March 10, 2005

RE: PROP, 131 – 133 Anderson St. Portland, ME  
CBL: 012 B0- 09

We've reviewed the list of comments on the submitted plans and listed below where the information is located, or what our proposed solution will be. Once reviewed and approved we will assemble an Addendum to incorporate the revisions as necessary. I've also attached your letter for easy reference.

M1.0

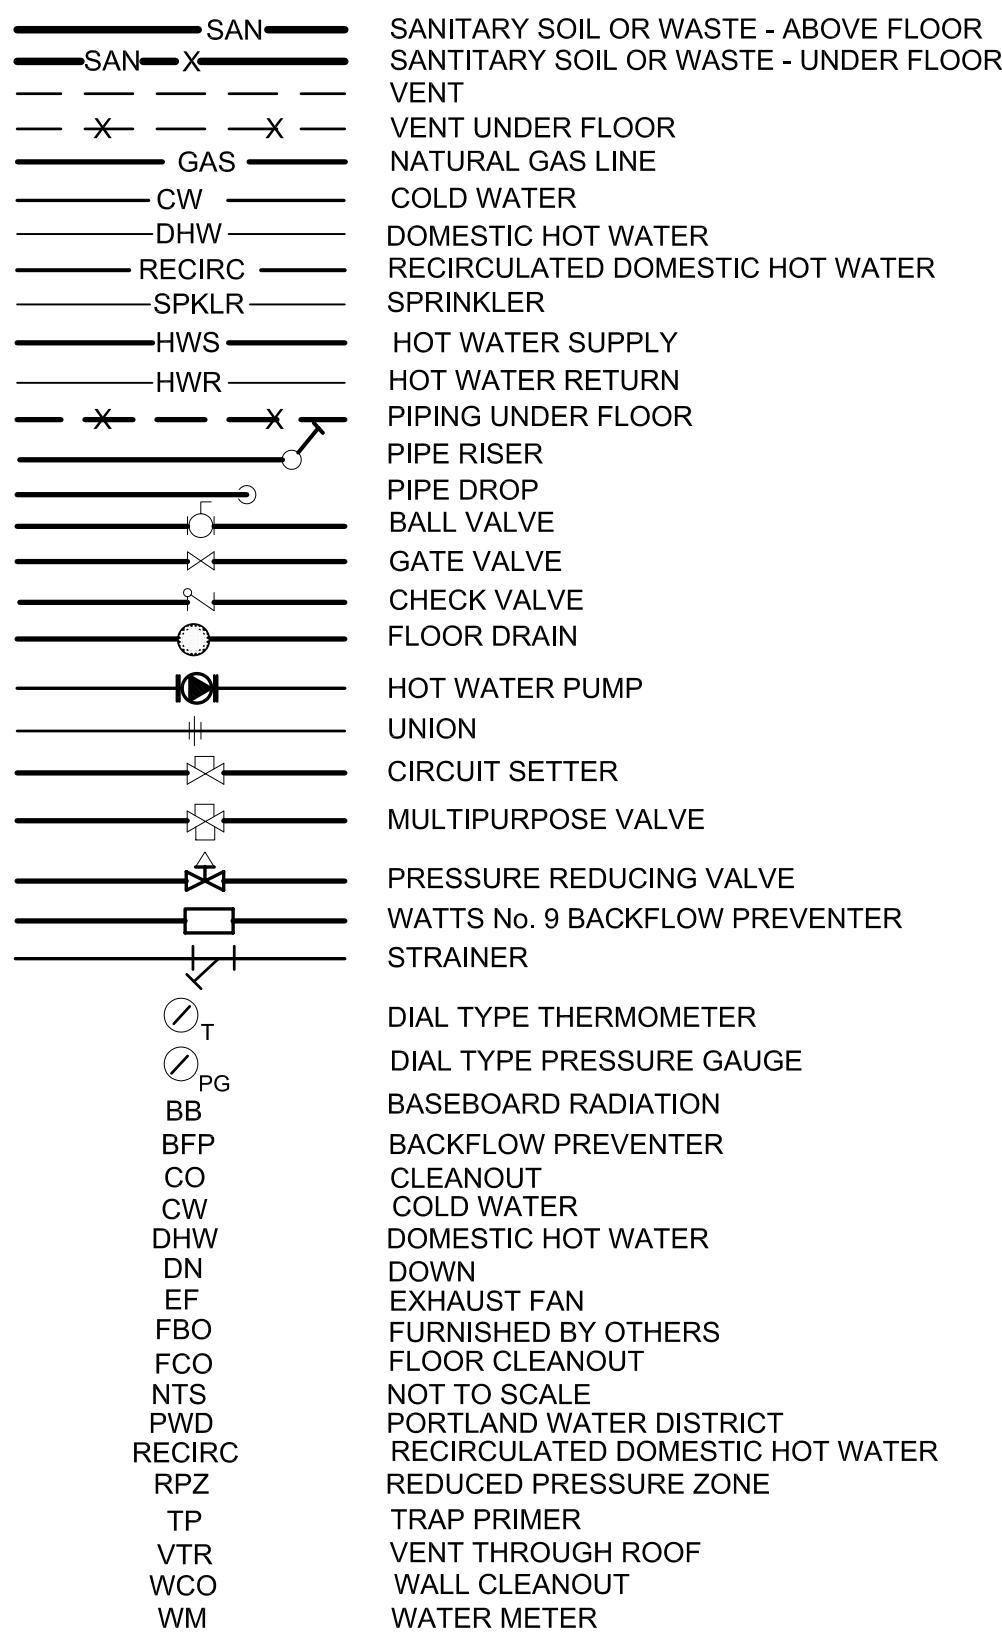
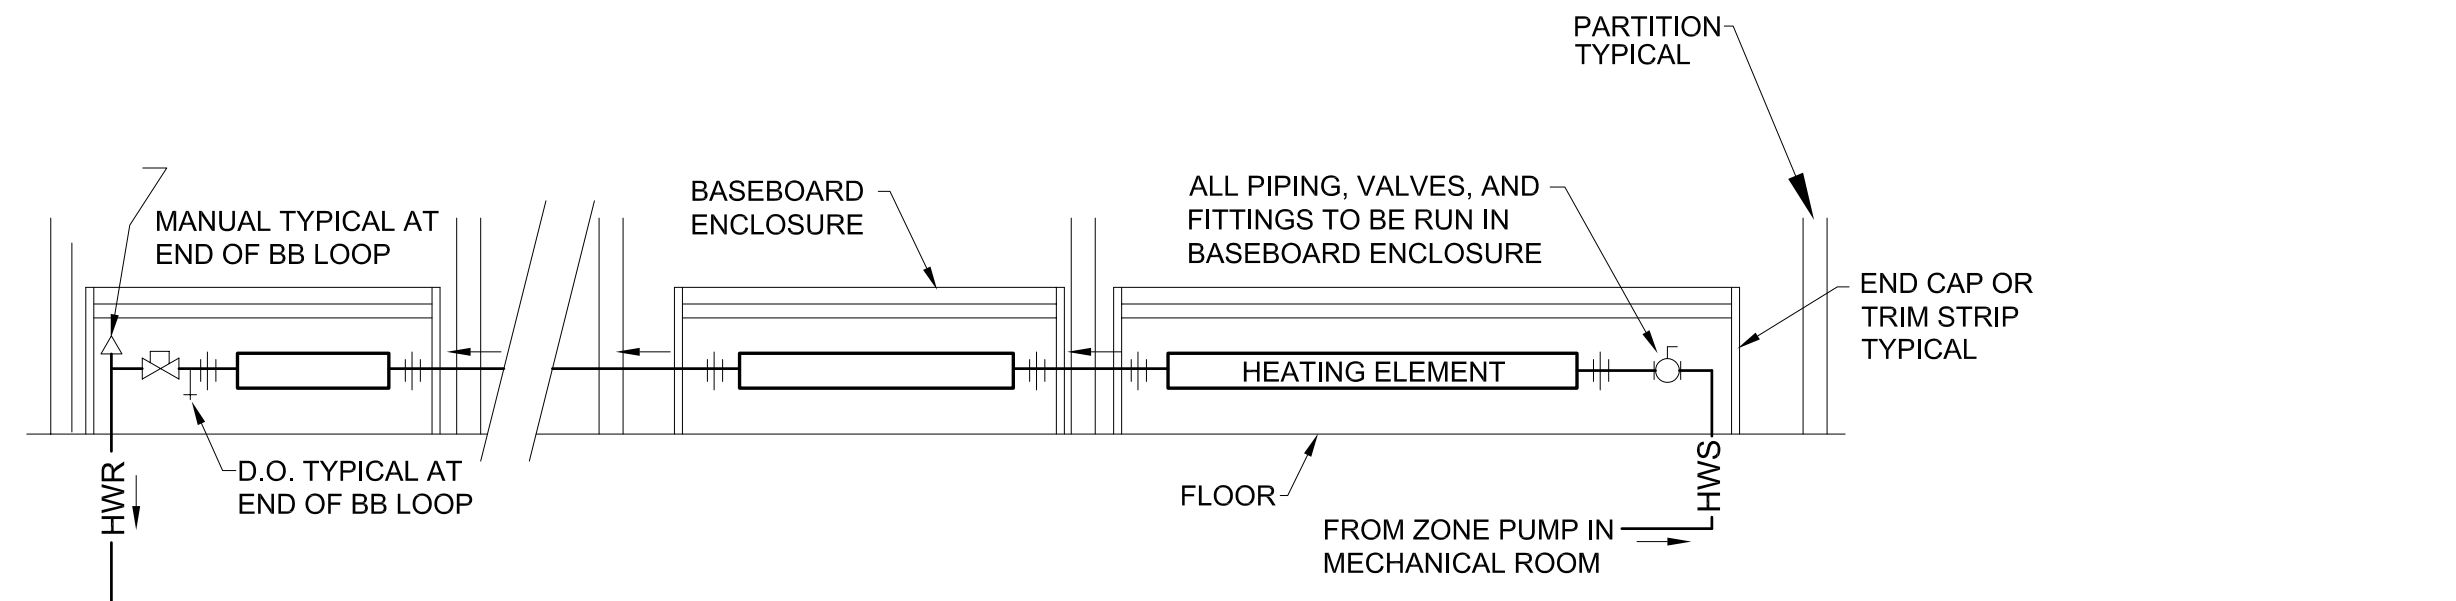
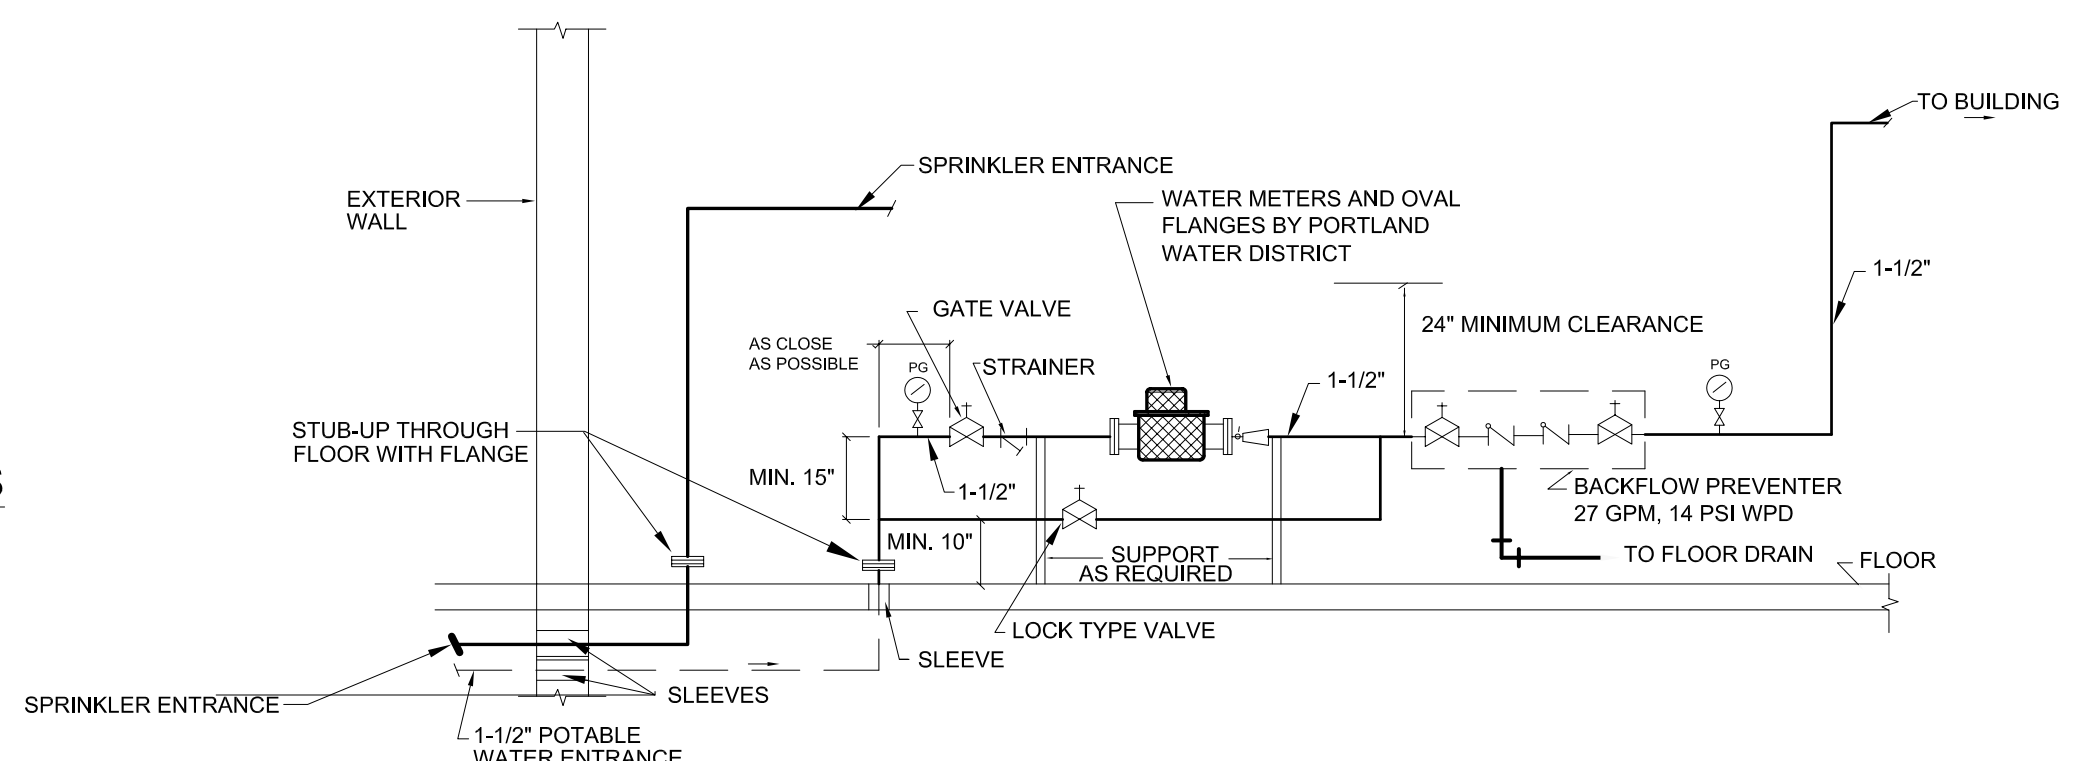
8. Sheet M1.0 indicates typical mechanical fire penetrations. I have also attached the typical fire penetration detail we use when not covered by the Mechanical typical details. We will incorporate this into the documents. The intent for all the routing of dryer, bathroom & kitchen exhaust is to directly exit the building in as short a route as possible through the unit serviced. There should not be any instance of exhaust entering the shaft. If at any point a duct penetrates a rated assembly on its route to the exterior, we will install an appropriate fire damper.
